# Rezoning Transportation Analysis

Petition Number: 2022-174

Date	Description
2-22-23	First Review (IW)
03-22-23	Second Review (IW)

SITE PLAN SCALE 1:20

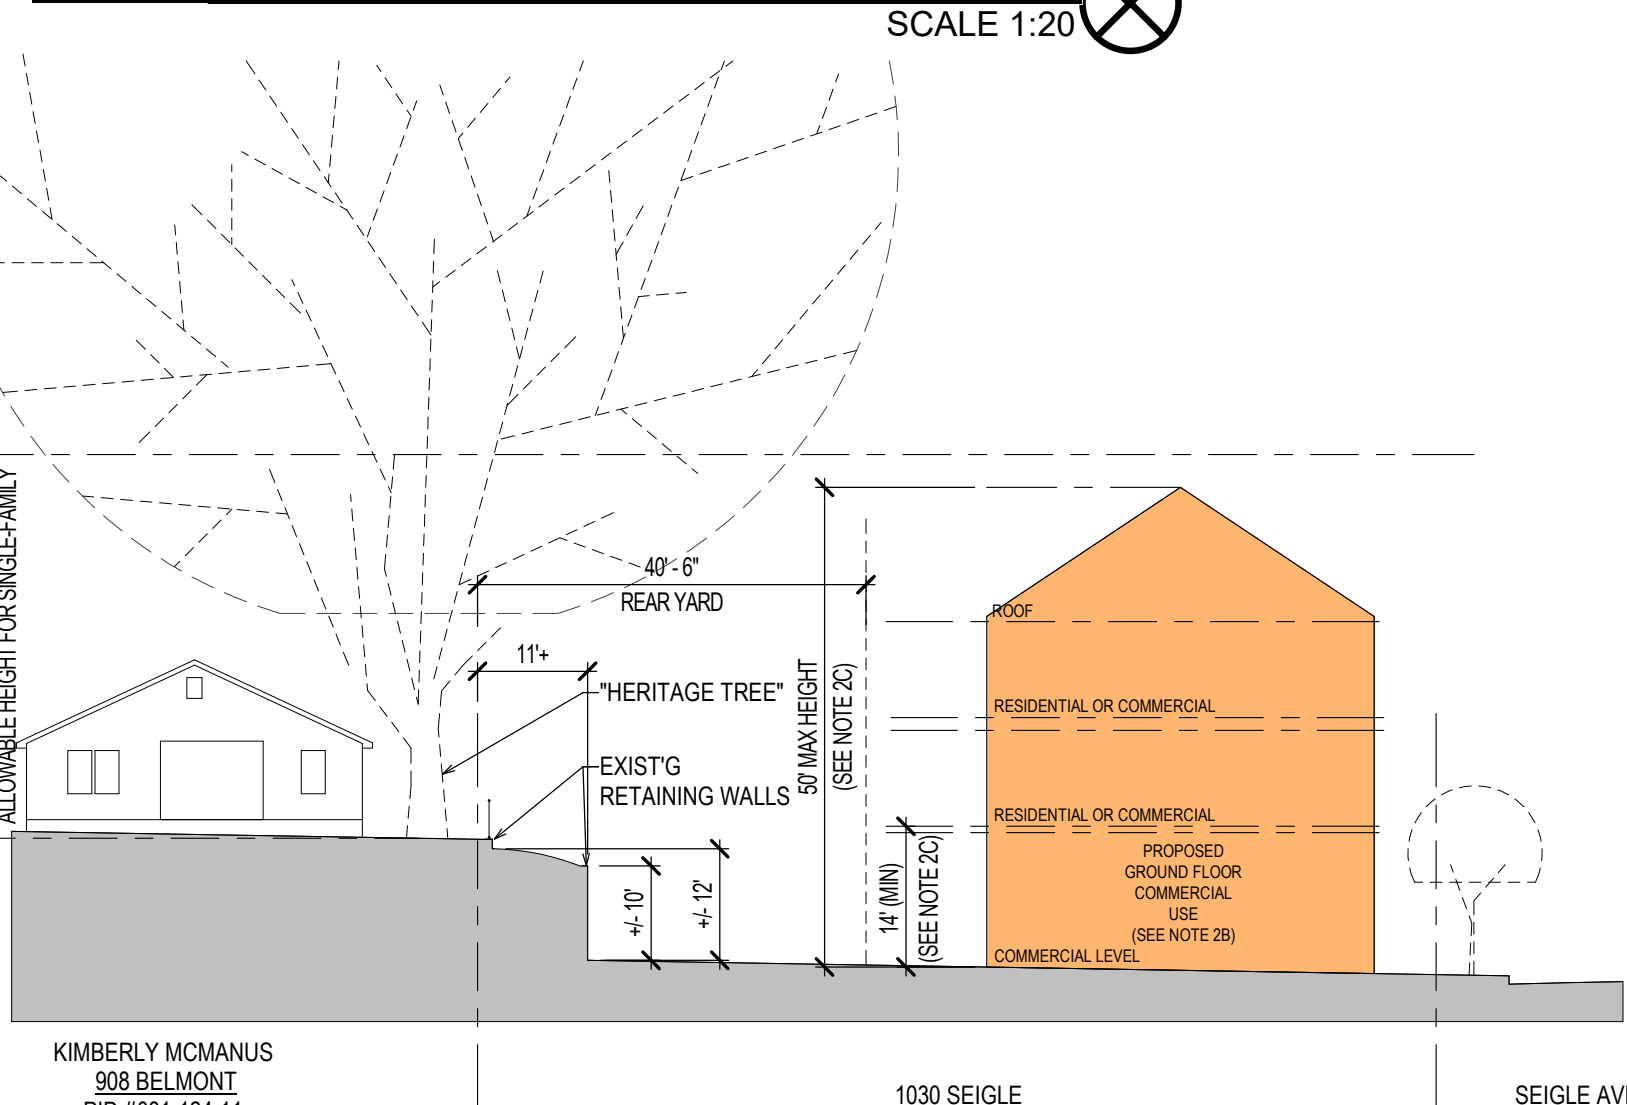
1. **Outstanding Comment from 02-22-23 Curblines:**

- a. **Belmont Avenue:** Location of curb and gutter to be moved to 15 feet from roadway centerline to accommodate the Charlotte Streets Map with a roadway typical section of Local Collector CLDSM U-07.
- b. **Seigle Avenue:** Location of curb and gutter to be moved to 18.5 feet from roadway centerline to accommodate the Charlotte Streets Map.

**Clarifying Comment from 03-22-23** Existing curb and gutter can remain in existing location but label and dimension the future curb and gutter location from the centerline for each road on the site plan.

**Clarifying Comment from 03-22-23:** Site plan shows 25' to centerline but does not show the existing 50' from centerline. Label and dimension the existing 50' right of way from centerline of road.

5. **Outstanding Comment from 02-22-23:** Revise site plan and conditional note(s) to commit to construct an 8-foot planting strip, and 8-foot sidewalk on Seigle Avenue per Chapter 19 and to support the council adopted Charlotte Streets map. The site plan shall label and dimension both items from the back of curb and gutter or edge of pavement.

**Clarifying Comment from 03-22-23:** CDOT REQUESTS petitioner commit to 8' sidewalk and place Streets Map streetscape behind future curb location.

8. **New Comment 03-22-2023:** Petitioner should revise the site plan and conditional notes to show sidewalk utility easement on plans behind proposed sidewalk.

9. **New Comment 03-22-2023:** Petitioner should revise the site plan and conditional notes to show 10x10 triangles behind the sidewalk.
10. ~~Add a conditional note specifying "All transportation improvements will be approved and constructed before the site's first building certificate of occupancy is issued. The petitioner may phase transportation improvements if said improvements and phasing are explicitly described in site plan notes."~~
